Case Reference: NA29N.314724

Railway (MetroLink-Estuary to Charlemont via Dublin Airport) Order 2022

Submission on behalf of Alstead Securities in relation to Ashford House, Tara Street, Dublin 2

TARA STATION

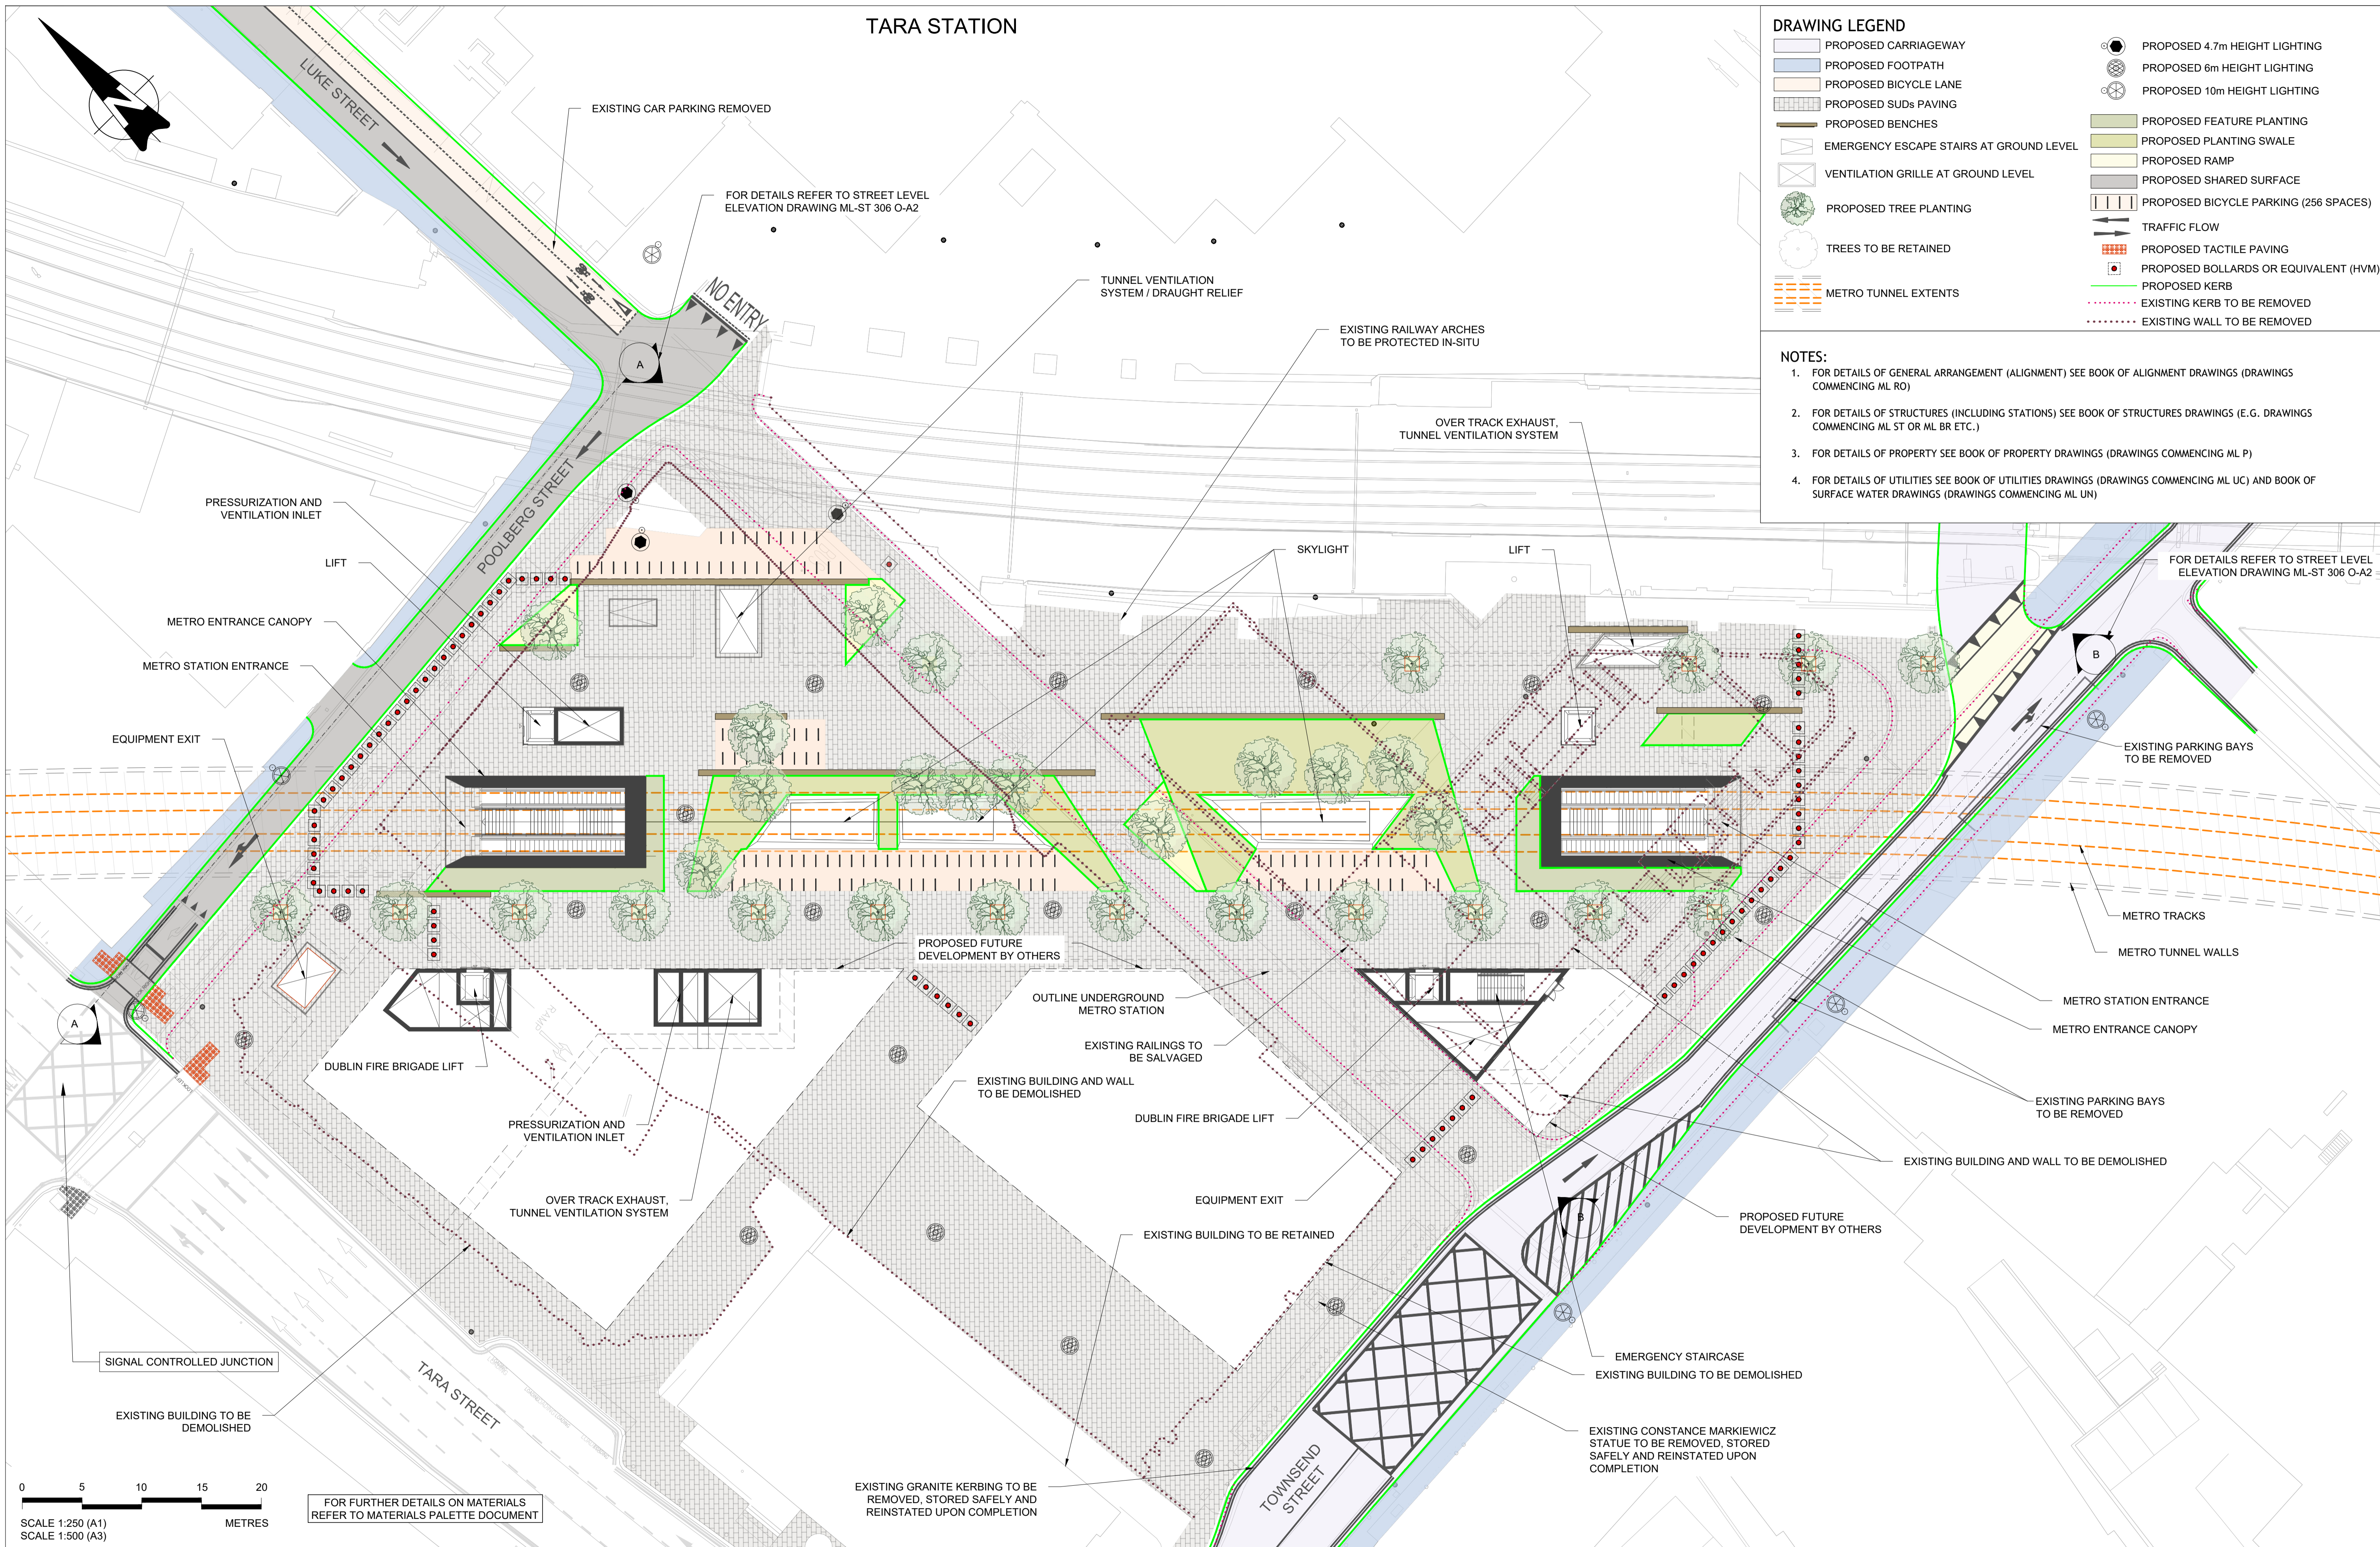
The Draft Railway Order proposes the Tara Street station on the site of Ashford House and adjacent sites. The proposals retain an area for 'Proposed Future Development By Others' which is mostly contained within the current ownership of Alstead Securities. The proposals show the creation of an underground station with entrances at the Poolbeg Street and Townsend Street ends of a large plaza which is proposed at street level (**Figure 4**).

As shown, an area marked 'Proposed Future Development By Others' over washes Alstead Securities landholding as shown in blue on **Figure 4**. This area of 'Proposed Future Development by Others' comprises c. 840m². It is an irregular parcel of land and its development for a viable new building is severely compromised by the shape and configuration of the parcel of land left over after the Metrolink proposals.

In addition, the Metrolink proposals include a number permanent structures at ground floor / surface level of the future of the future development site, including for example a fireman's lift. This is a very poorly considered arrangement and will severely impact development potential of the site.

Further to this, the creation of a public plaza at this location has not been well considered. The plaza will be overshadowed by neighbouring buildings resulting in a lack of sunlight, and will not offer positive public realm as the majority of users of both the DART and MetroLink Stations will pass through the area quickly to access transport. Opportunities for commercial development feeding into this square, both from retail/food and beverage at ground level and from offices at upper floors, has not been considered. New public plazas should be carefully planned with future users in mind; it is considered that this plaza has been created as a result of a left-over area of land and will offer little by way of public amenity. The creation of this plaza is by virtue that it is easier for the MetroLink project to have nothing above the station than to give detailed consideration to the function of this area which would result in a better outcome for all.

- The permitted scheme should accommodate development above the MetroLink station. This would better achieve the aims and objectives set out in policy to promote development at sites with excellent public transport links.
- Development should be allowed in advance or alongside the MetroLink construction stage so as to not sterilise the owner's lands. Appropriate protection for the proposed MetroLink scheme can be incorporated in the development above.
